**WEST SUSSEX COUNTY COUNCIL
INFRASTRUCTURE CONSULTATION**

SUBJECT: BR/210/10 - Demolition of existing commercial unit and provision of 5 houses.

Land at, 34, Dorset Road, Bognor Regis, West Sussex, PO21 2DU

DRW NO 9 SCALE 1/200
PROPOSED LAYOUT

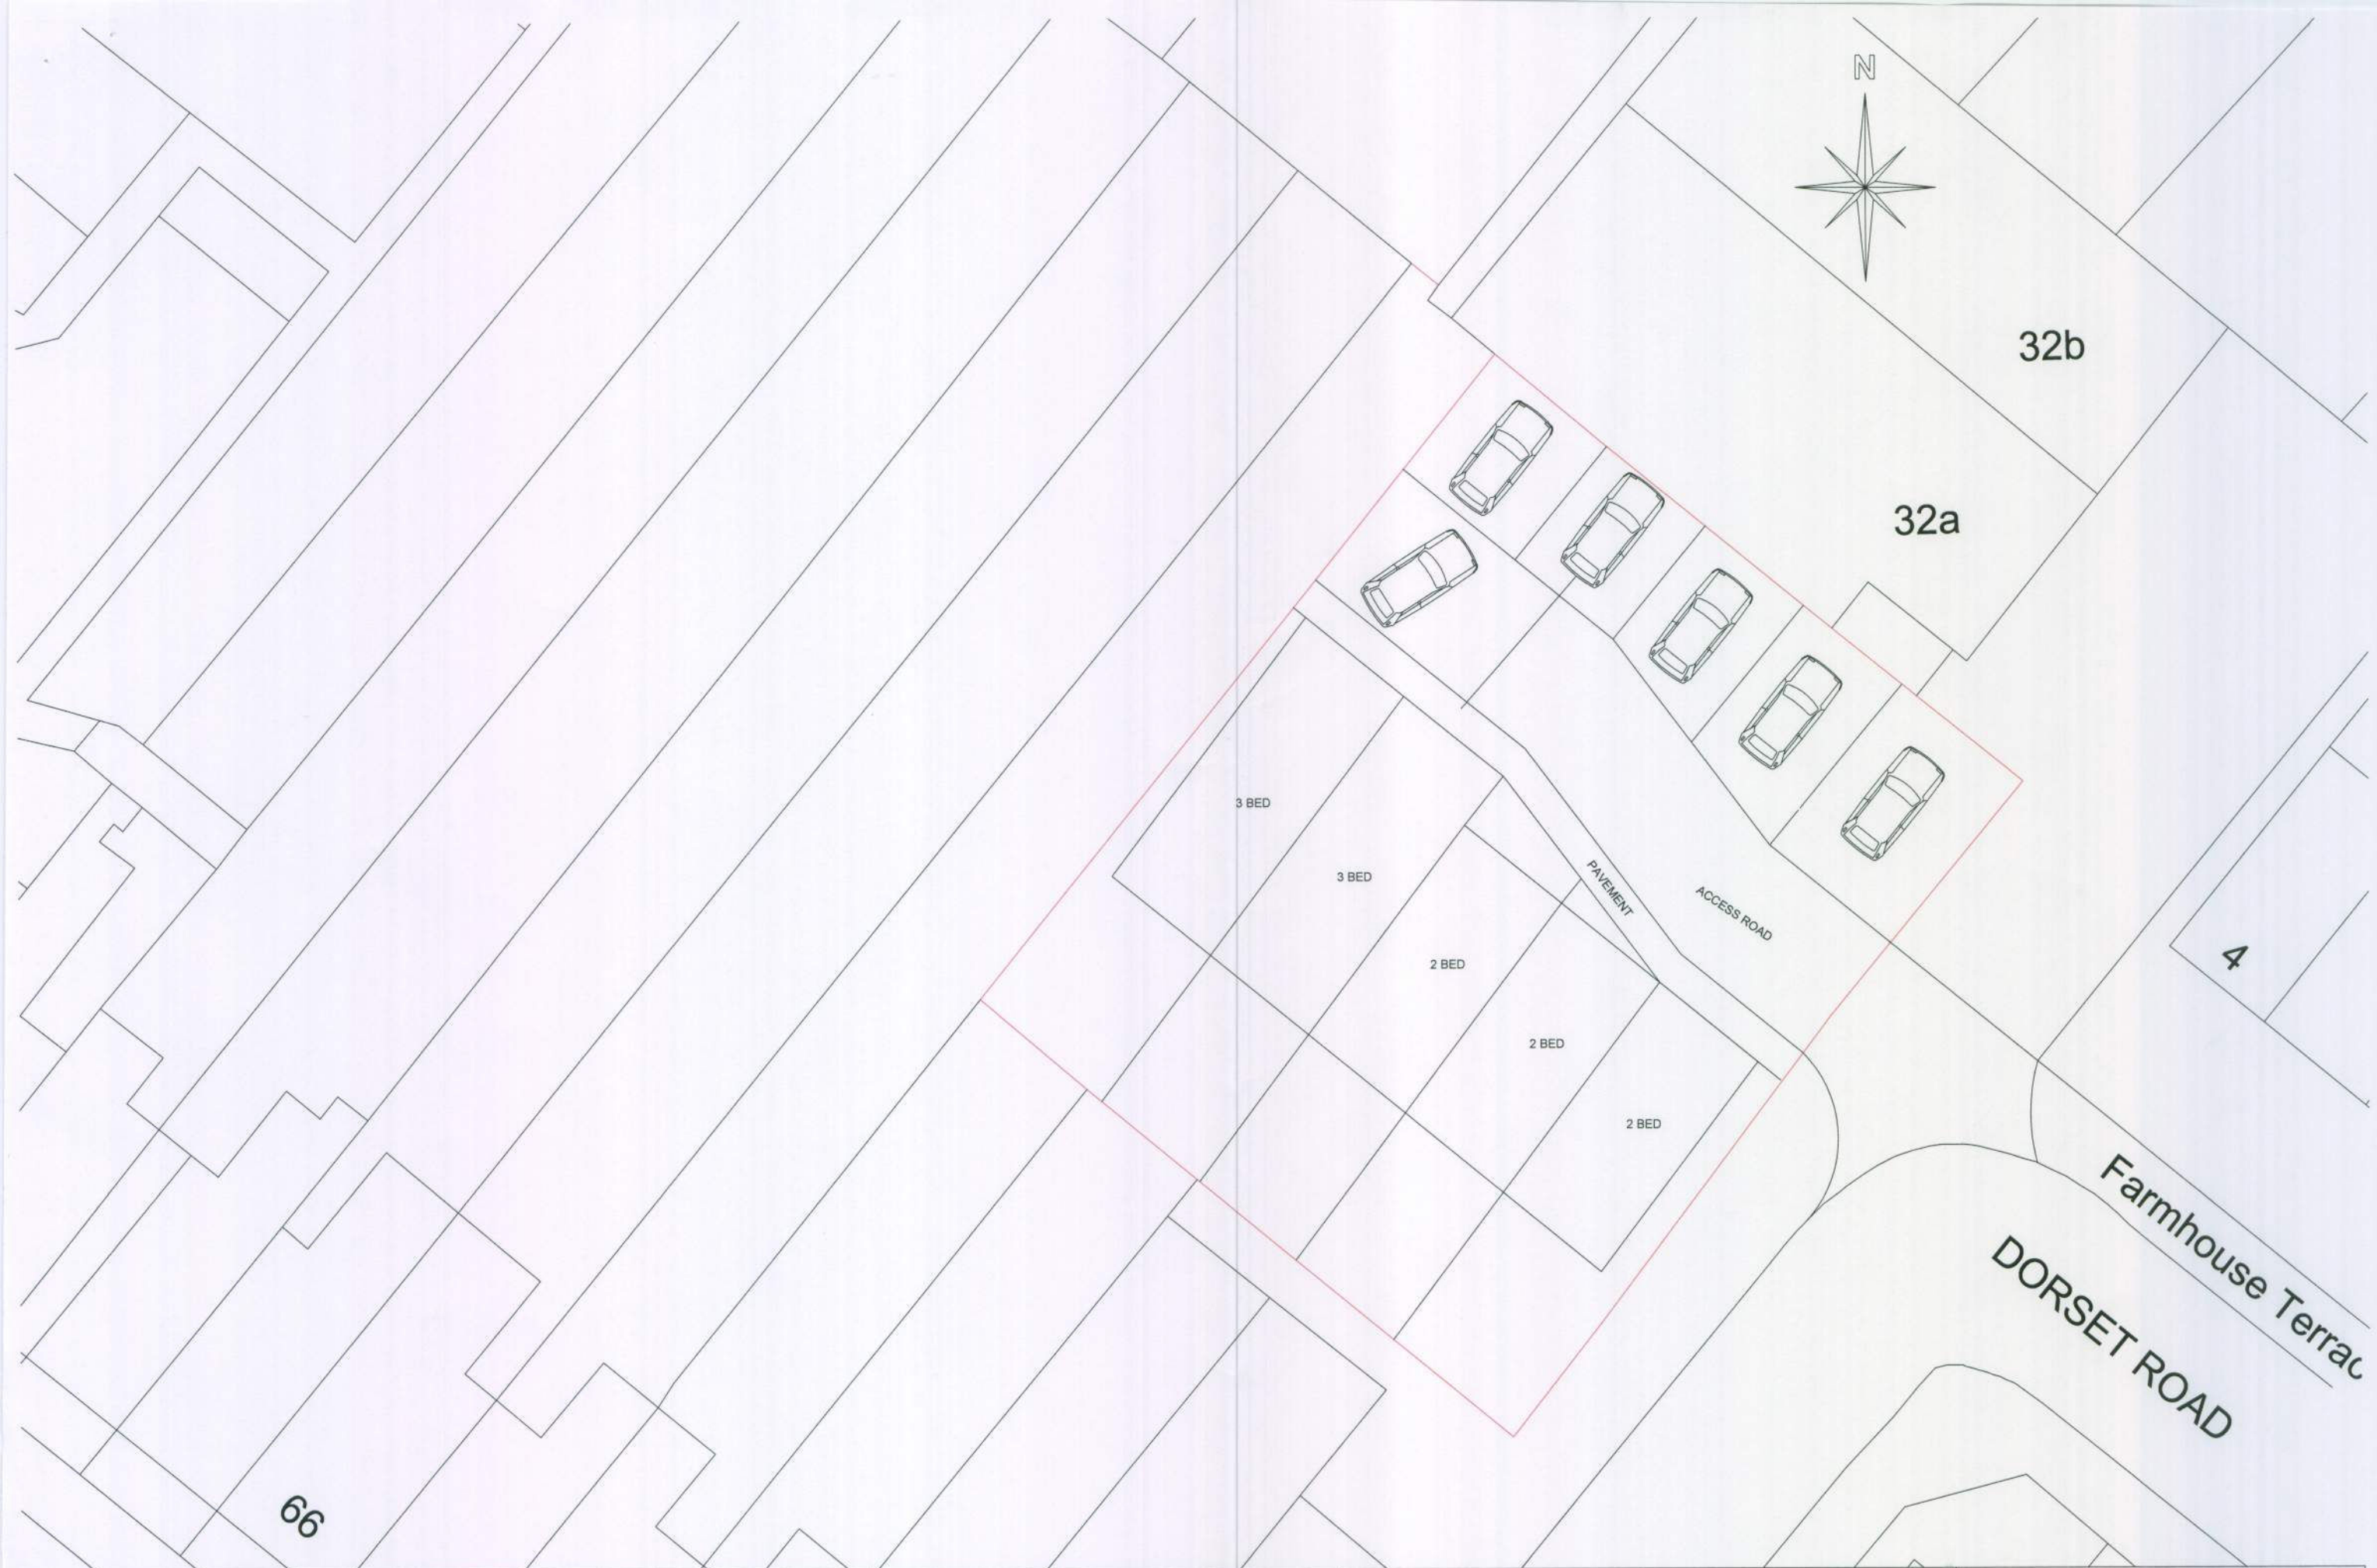
The proposal is for the demolition of the existing commercial unit and the provision of 3 no. 2 bed dwellings and 2 no. 3 bed dwellings with access onto Dorset Road via an existing access point. From an inspection of the plans alone, there is no apparent visibility issue at the point of access onto Dorset Road. The most recently available verified accident records reveal there have been no personal injury accidents in the vicinity of the existing point of access.

Concerns were raised at the pre-application stage that residents may try to utilise one parking space for the parking of two cars if the spaces are too wide. This issue does not appear to have been addressed through the current plans. It is also unclear as to whether a vehicle would be able to turn within the site.

Although the principle of this proposal was found acceptable at the pre-application stage, further details are required to determine this application. The applicant should provide details of the width of the access road, the car parking space dimensions and the width of the proposed pavement to allow an assessment of whether these comply with current design standards.
